Your Ref: OWPC14568
Our Ref: FP/152/17/HH
Please ask for:
Mr R Temple

Additional off street carparking
14 Derwent Grove Felpham

Thank you for your internet comments made on 12th July 2017 which has been recorded as **'an objection'** with the comments as follows:

Metres
14 Derwent Grove
Felpham
Layout Plan 1:200
A4 Paper

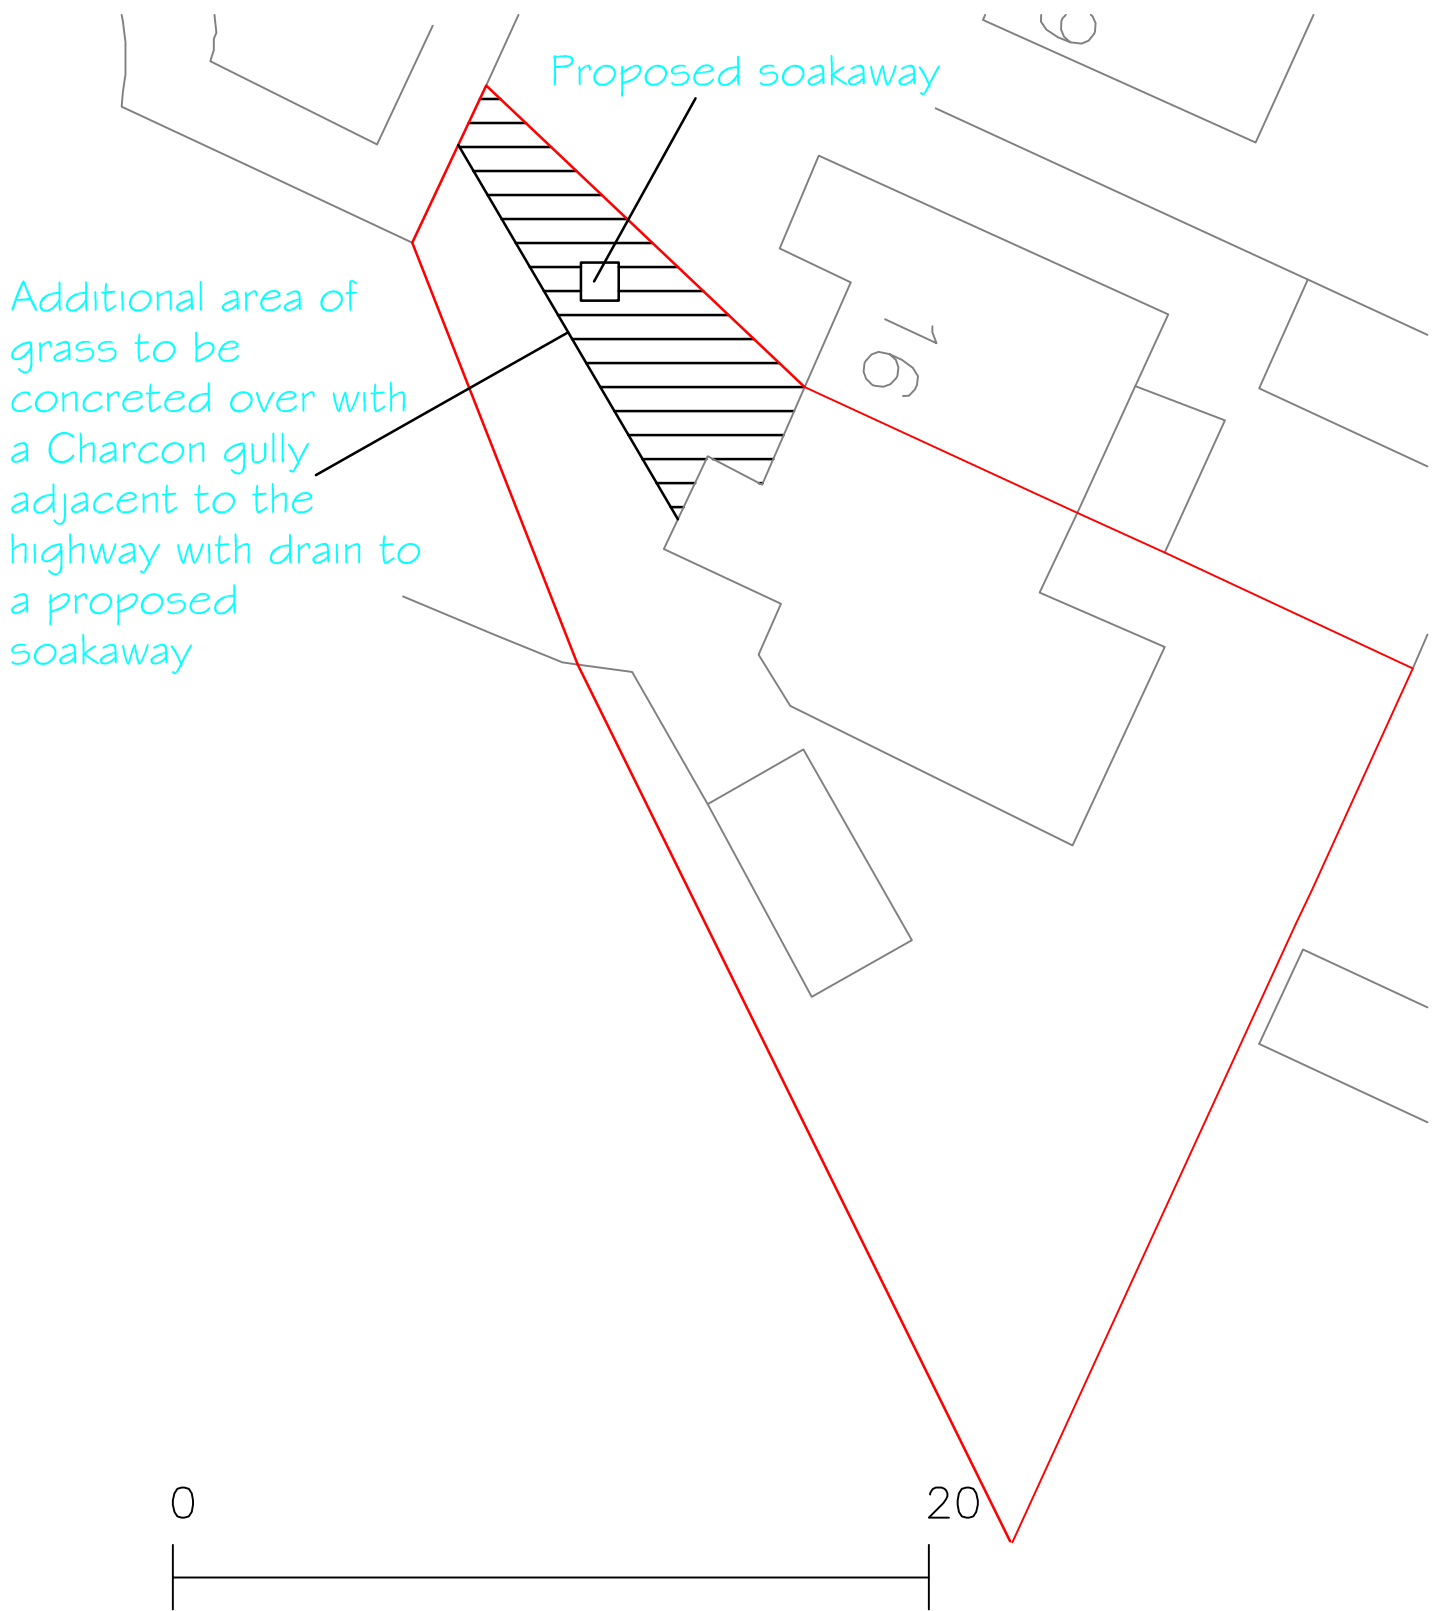
Objection - no permeable solution here - absence of flood management.
